Sent: 30 August 2010 21:50
To: Lisa Hughes
Cc: Planning
Subject: Gascoyne Cecil Estates Planning Application for replacement car parks
Attachments: Hatfield House Planning Applications Aug 2010.doc

Planning Application S6 2010/1711/FP

**Gascoyne Cecil Estates ["GCE"] Planning Application
for Replacement Car Parks
Application number S6 2010/1711/FP**

DRAWING NUMBER:
045-VC-002 B

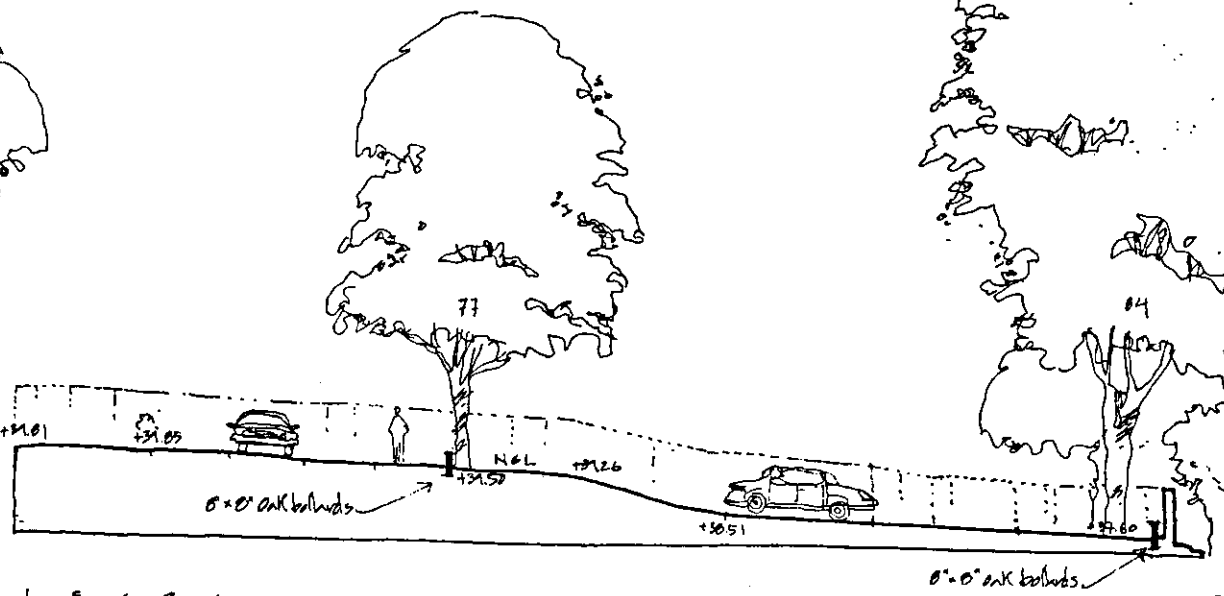
Firstly, the Plan Proposals Map [Figure 7, page 21] gives a misleading impression regarding the extent of the proposed car park, edged in red ink. As the Site Plan [Figure 6, page 14] clearly shows, the area comprising the proposed car parking bays for the residents of Park Row Cottages – the four semi-detached properties on the south side of the proposed car park- has been omitted on Figure 7. If these proposed car parking bays and two lane "new

private access road" are inked in on Figure 7 it becomes immediately apparent that a considerable proportion of the existing rear gardens of these four cottages [in particular the more northerly cottages nos 1 & 2] will be lost to the development. All four cottages are owned by the Estate. Three of these cottages are currently unoccupied.

Secondly, although no mention is made in the Planning Application, the Site Plan [Figure 6, page 14] infers that the two lane private access road extends in a southerly direction beyond the residents' parking bays, through what appear to be substantial gates....into an unnamed, unmarked area. This area is the garden of Whitesmiths Cottage, the property that I rent from GCE. Currently, vehicular access to Whitesmiths is, and has been for many years, through the Carters Row "courtyard" into a single track driveway – a perfectly satisfactory arrangement. Why replace this with a two lane "new private access road" that would entail the "loss" of Park Row Cottages' rear gardens and much extra noise to the nearby residents of Park Close?

Why, unless there are as yet undisclosed future plans to extend the two lane access road a further 10 metres through Whitesmiths' garden into the adjacent large orchard area that extends to Fore Street?
